Response to Planning Application

From: Arun District Council Leisure & Greenspace

Application ref: AL/129/21/OUT

Location: Land adjacent to Woodgate Nurseries Lidsey Road Aldingbourne PO20 3SU

SURFACE WATER STRATEGY

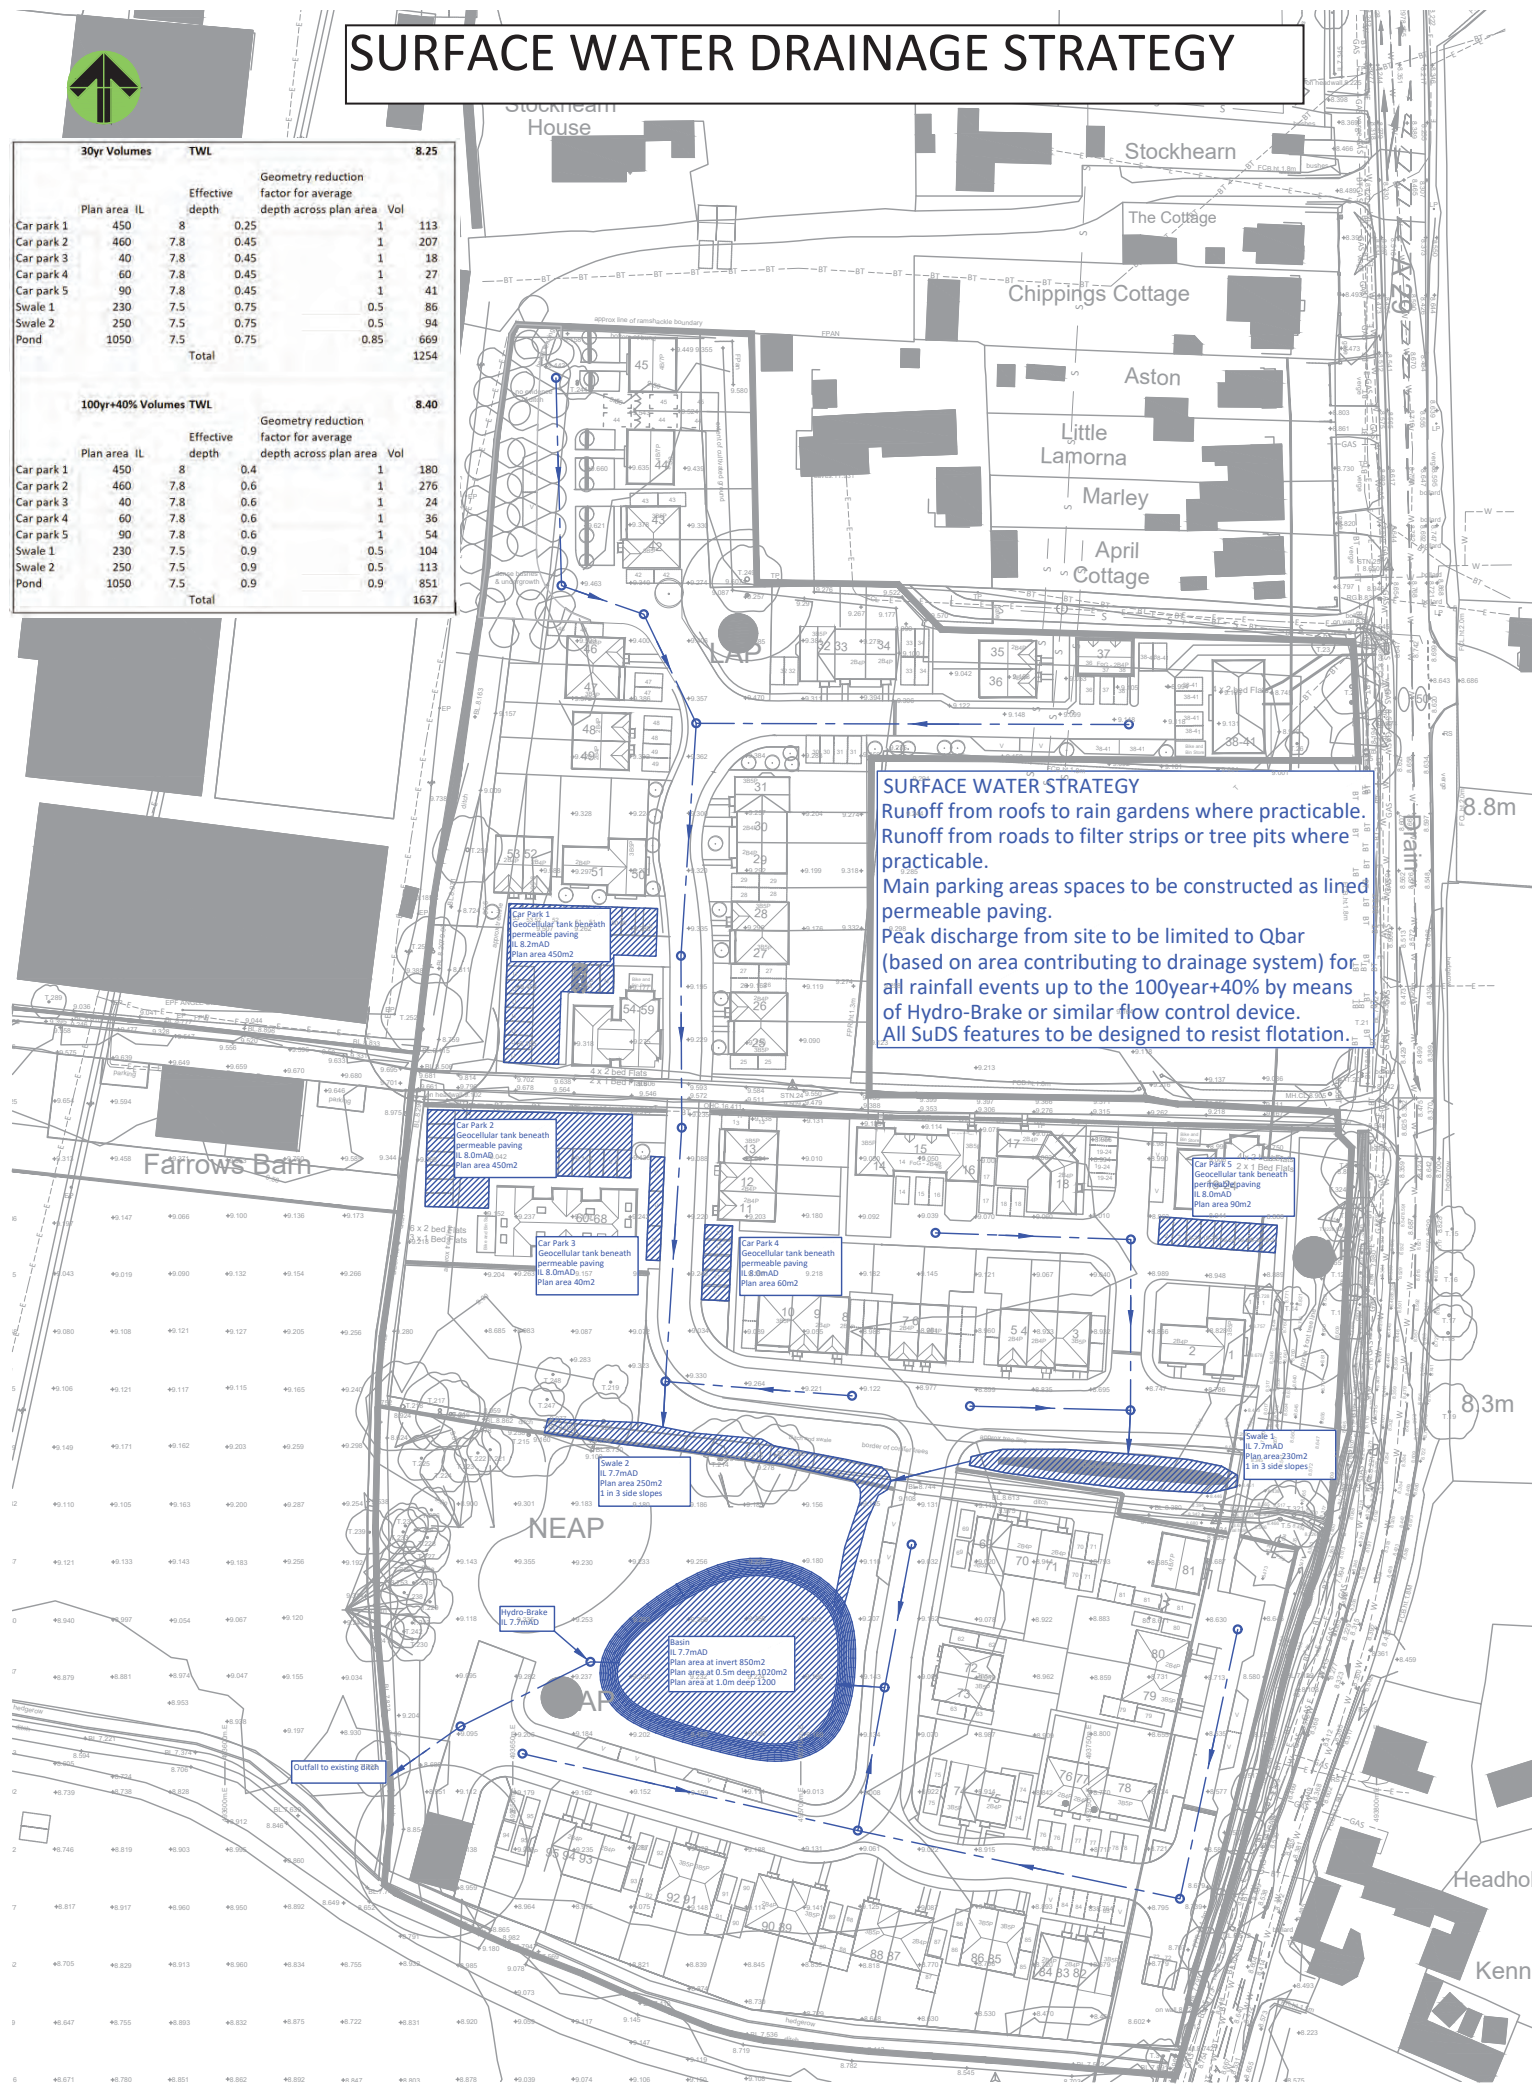
This development will trigger the requirement for play in the form of onsite LAPs and LEAP provision, which would need to be suitable for location in material choice and play experience offer. Both LAP and LEAP have been indicated however the illustrative masterplan shows an area of SuDS within the POS area and adjacent to the proposed LEAP.

Concern should be noted re the SuDS position in proximity to play and RoSPA or similar will need to be consulted re suitability of the proximity of the SuDS to play. Further detail would need to be submitted with cross sections indicating depths and perceived water holding timescales of the SuDS in this location.

SuDS Policy W DM3 of the Arun Local Plan requires development to integrate SuDS into the overall design of the development. The primary purpose of SuDS is to minimise the impact of urban development on the water environment, reduce flood risk and provide habitats for wildlife. SuDS should increase the levels of water capture and storage. It is essential that SuDS do not impact on the usable levels of public open space whilst providing benefit in the correct capacity within the development and should not be included in the 'usable open space calculations' SuDS feature are presently shown within the POS areas.
